Application for a Non-Material Amendment Following a Grant of Planning Permission

Application under S73 for Removal or Variation of a Condition following grant of Planning Permission DC/22/00448 dated 11/04/2022. Erection of 2No dwellings Town and Country Planning Act 1990 - To vary Condition 2 (Approved Plans and Documents) amended scheme of plans.

DC/23/00903

Minor Variation to remove cladding from Plot 1 (west elevation); Internal layout changed to Plot 2 requires repositioning of windows to accommodate changes (north and east); removal of plinth brick.

NORTH PLOT 1

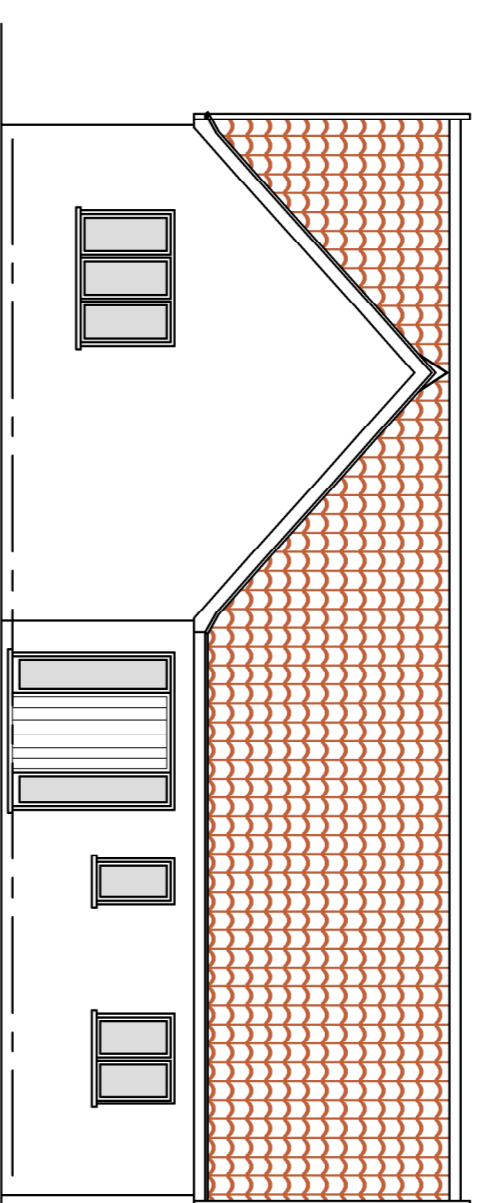
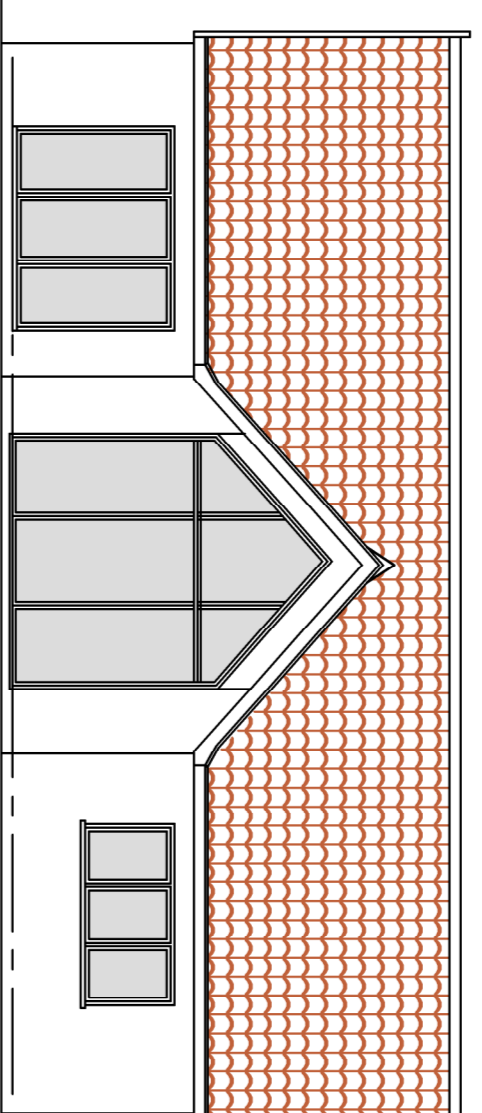
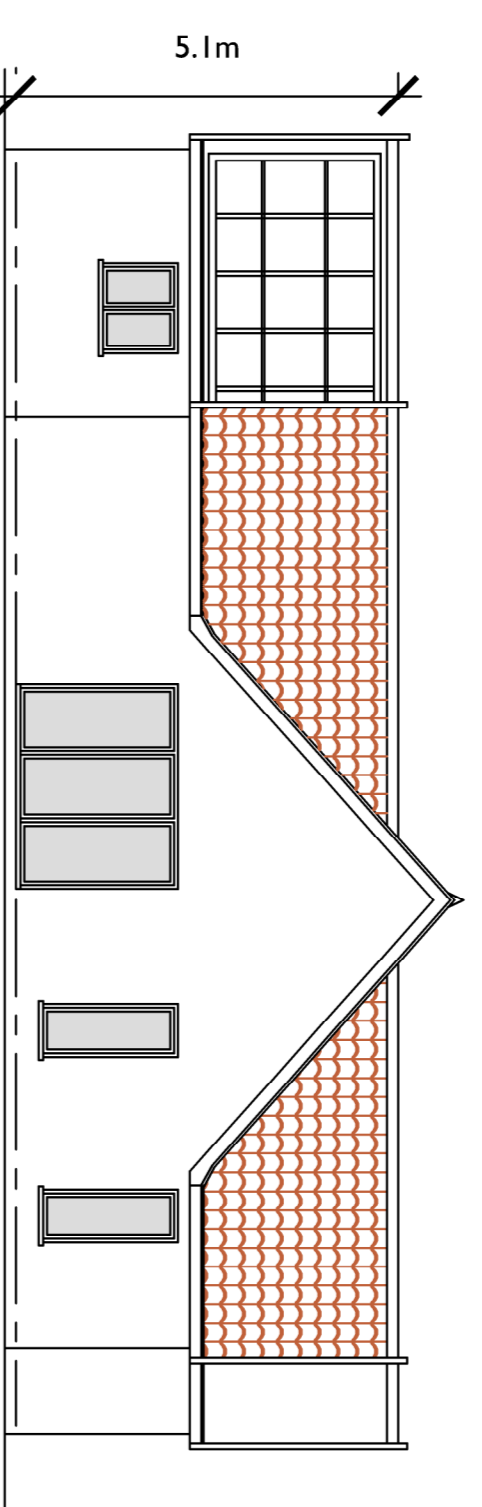
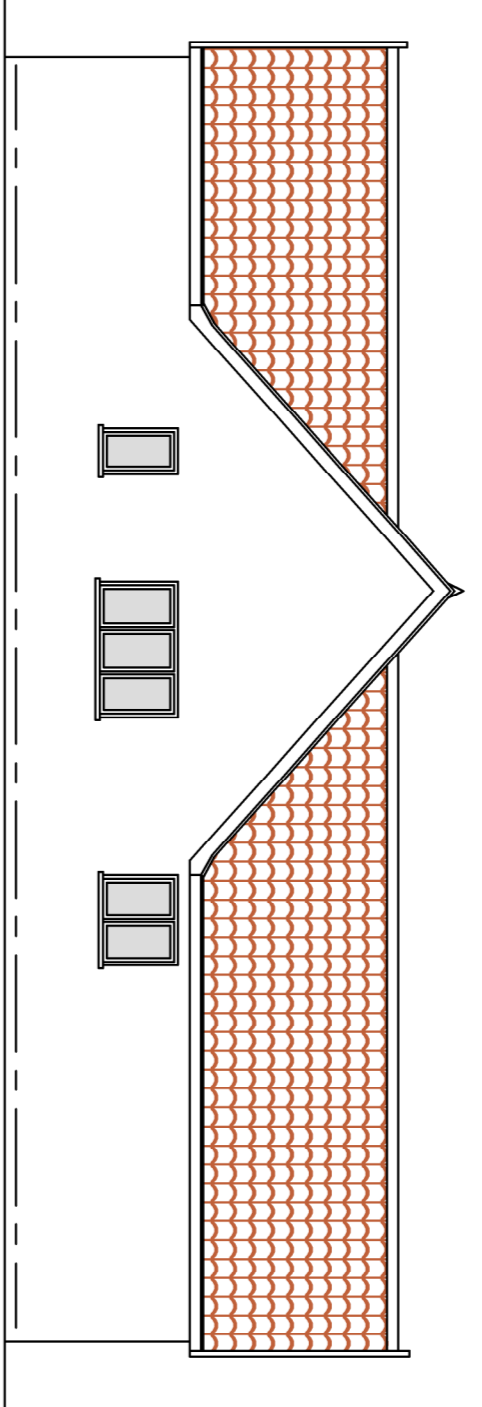
Improved Layout to Plot 2 & minor Design amendment to Plot 1, due to shortage of special bricks
